From: peter hake [REDACTED]
Sent: 13 August 2018 17:56
To: Anita Gardner
Subject: Fwd: EG/52/18/DOC - Application for approval of details reserved by condition imposed on planning permission EG/22/17/PL relating to condition 4 - Details of Construction

From: Anita Gardner <Anita.Gardner@arun.gov.uk>
Subject: EG/52/18/DOC - Application for approval of details reserved by condition imposed on planning permission EG/22/17/PL relating to condition 4 - Details of Construction
Date: 13 August 2018 at 15:29:51 BST

Mr Peter Hake
Project; Gravel driveway
Stoneyfield Nursery PO20 3SL
17/7/18

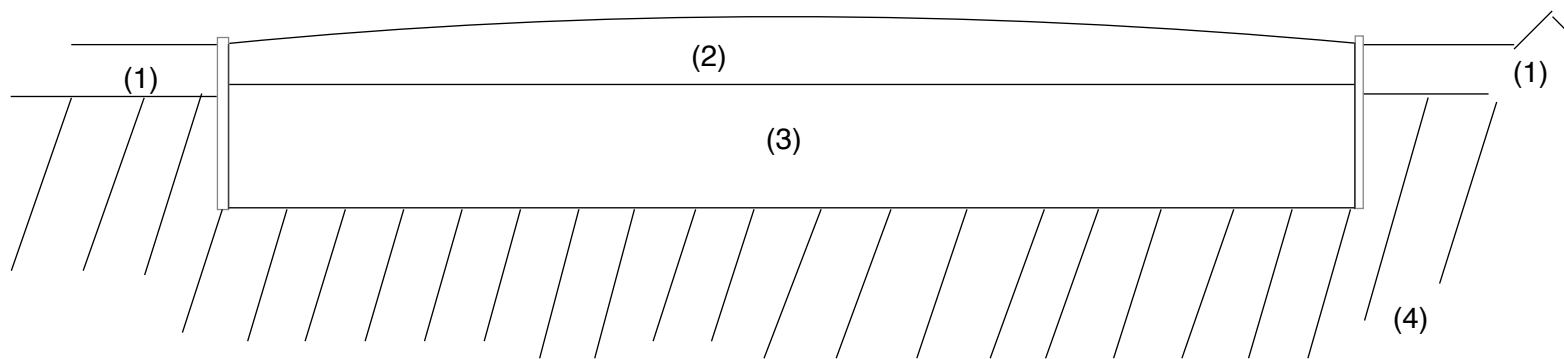
I have received the above application which contains a plan with very little detail. I would appreciate clarification as to whether it is a cross section or floor plan, together with the scale and where nos 5-8 (referred to in the Notes) are located.

The drawing is an indicative cross section but not to scale.

Note 5 draws attention to detail 3 on the drawing which is clean crushed hardcore to a depth of 400mm.

Note 6 refers to item 2 on the drawing which is a top surface of MOT type 1 rolled to 200mm thick.

Note 7 states that the width of the road will be 3.25 metres.

Note 8; States that a 6" timber edge will be installed along the whole road.
